Rezoning Transportation Analysis

Petition Number: 2020-086

General Location Identifier: Tax ID 04708214

Date	Description
07-22-20	First Review

SHEET NUMBER **RZ-3.0**

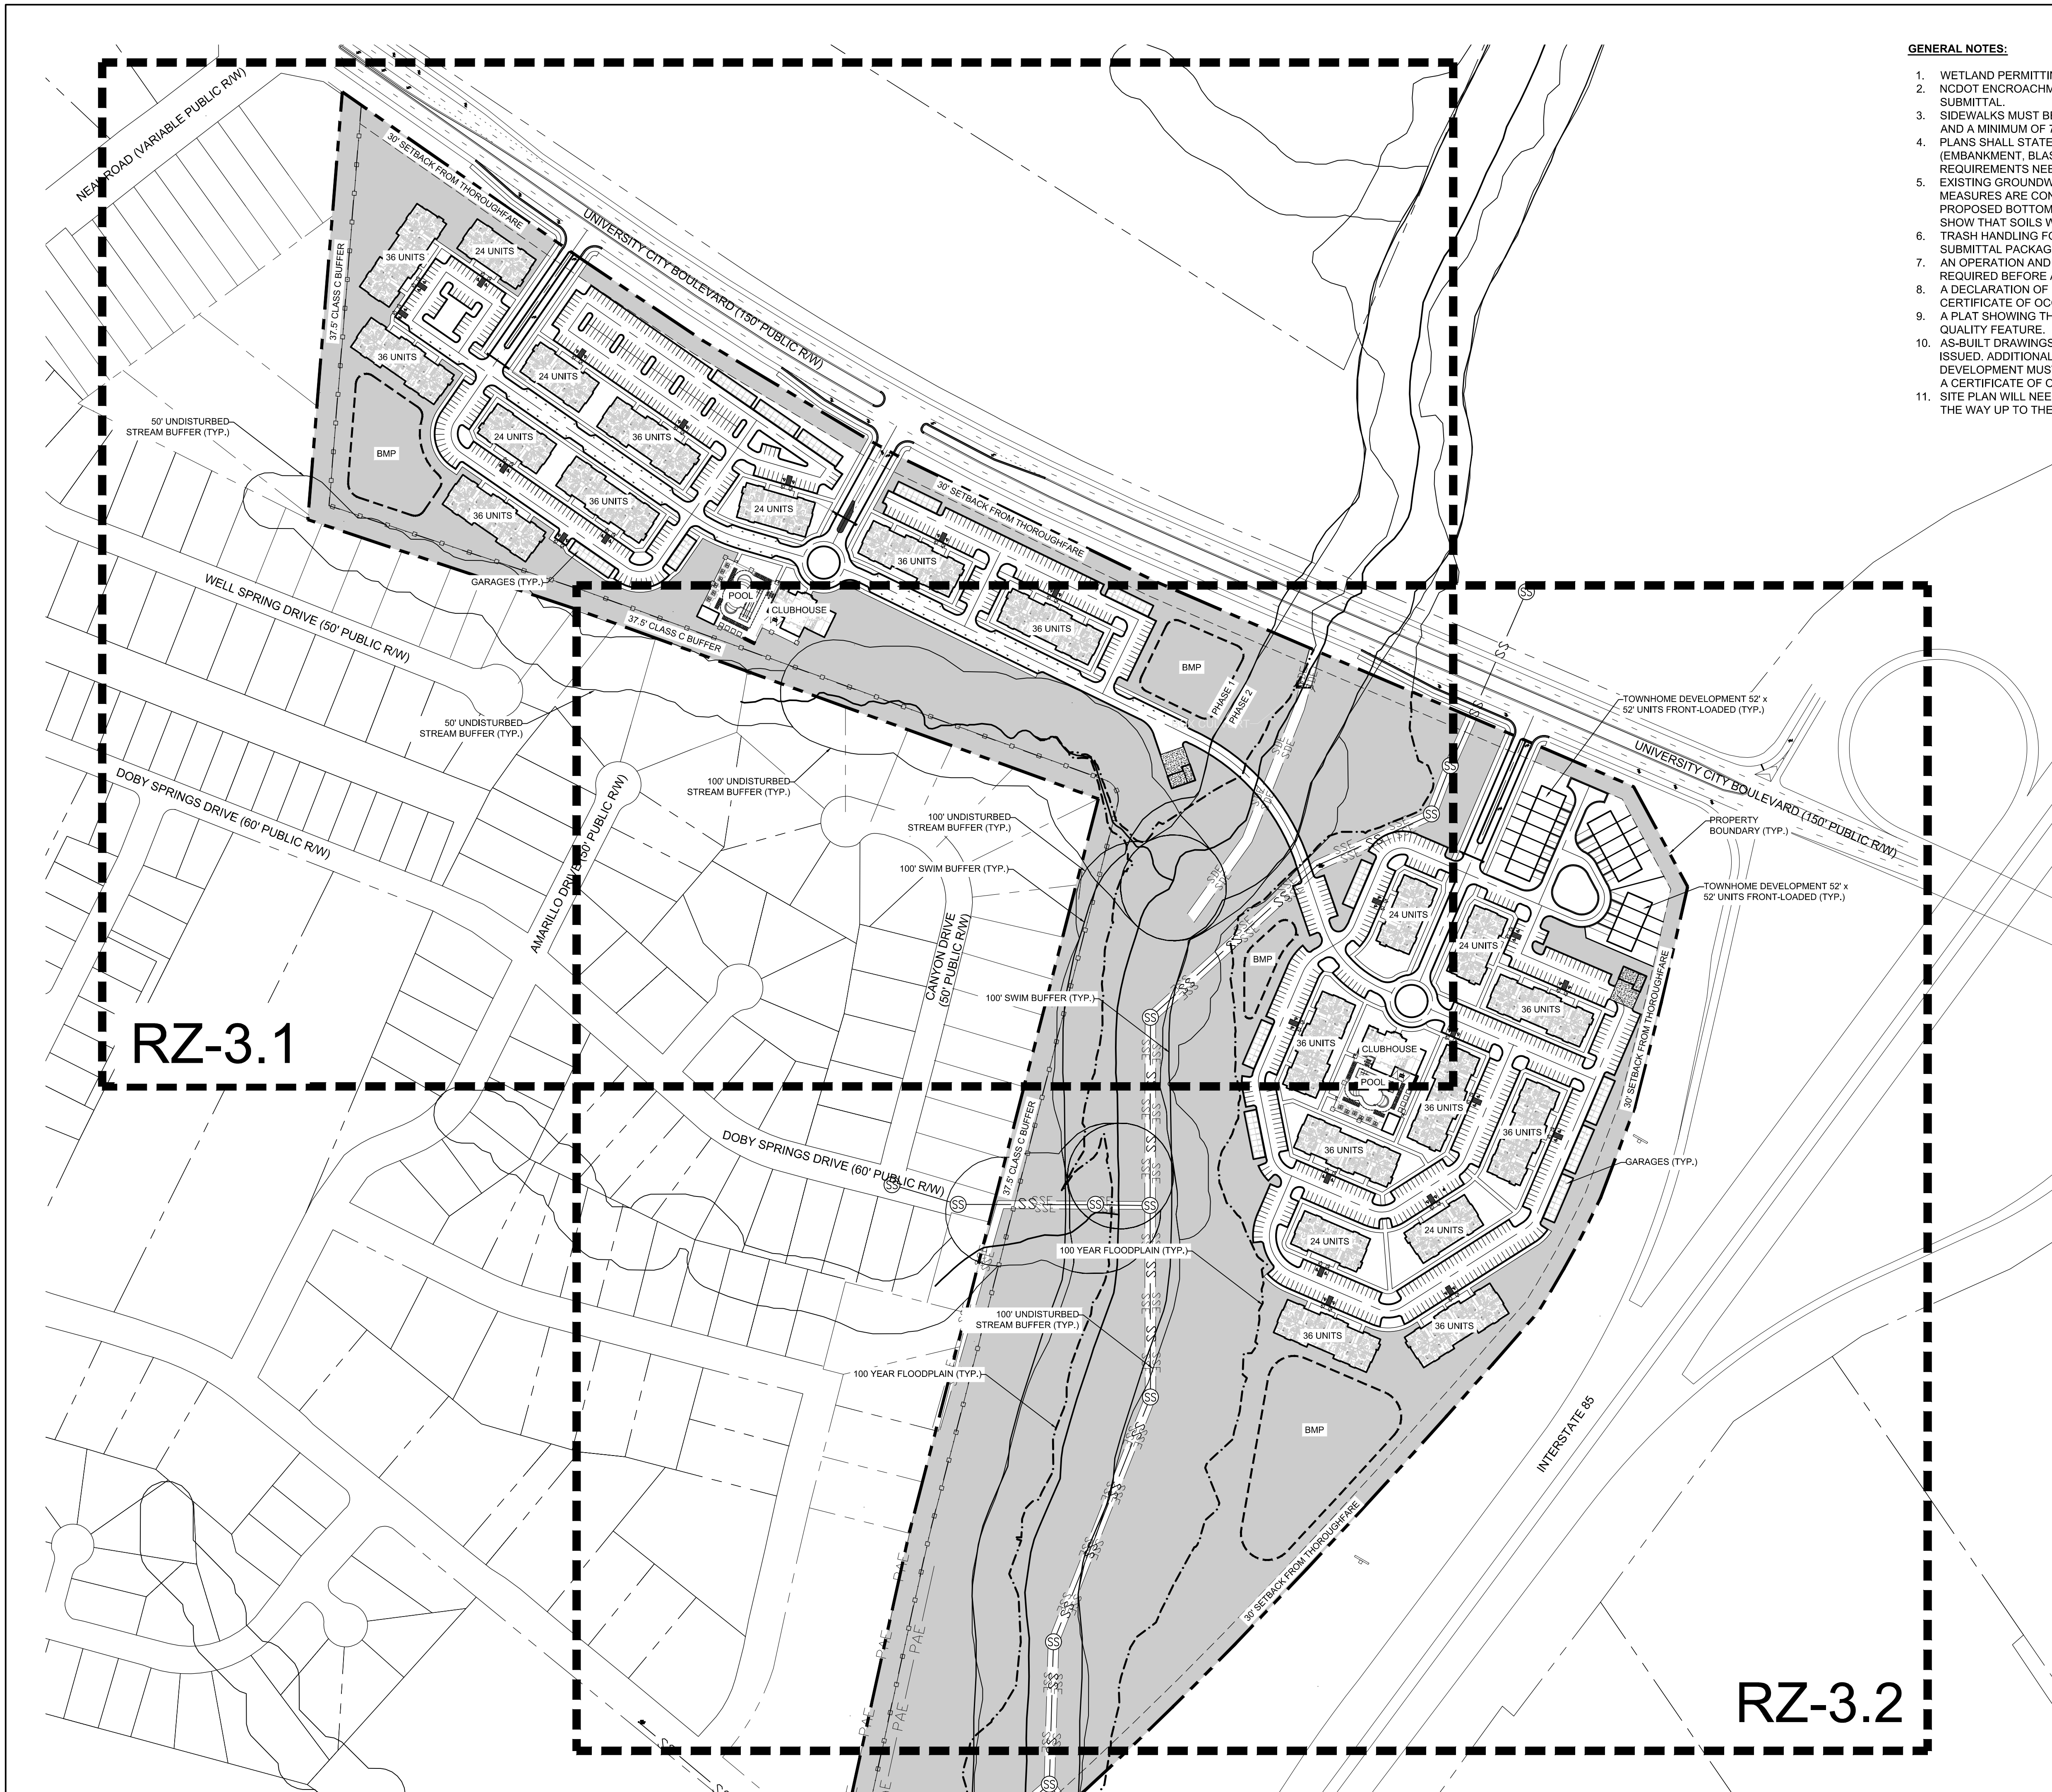
The site plan should show the curb and gutter labeled and dimensioned from the centerline for each road.

3. The petitioner should revise the site plan and conditional note(s) to commit to dedicating 50' minimum right-of-way from the road centerline per CRTPO. The site plan should label and dimension the right-of-way from the road centerline.
4. The petitioner should revise the site plan and conditional note(s) to commit to installing a 12' multi-use path along the site's frontage on University City Blvd to meet the City Charlotte BIKE Policy.

- The petitioner should revise the site plan and conditional note(s) to commit to constructing a shared use path from Doby Springs Drive including a structure over Doby Creek to provide pedestrian and bicycle access to adjacent subdivision in accordance with the Charlotte WALKS Plan and Charlotte BIKES Plan.

- The petitioner should revise the site plan and conditional note(s) to commit to constructing a Public street connection to Mineral Springs Road, including a box culvert over Doby Creek. to improve connectivity by providing a north south connection to access University Blvd.

strip, and 8-foot sidewalk along the proposed north-south public road. The wider sidewalk also meets the Charlotte WALKS Policy.
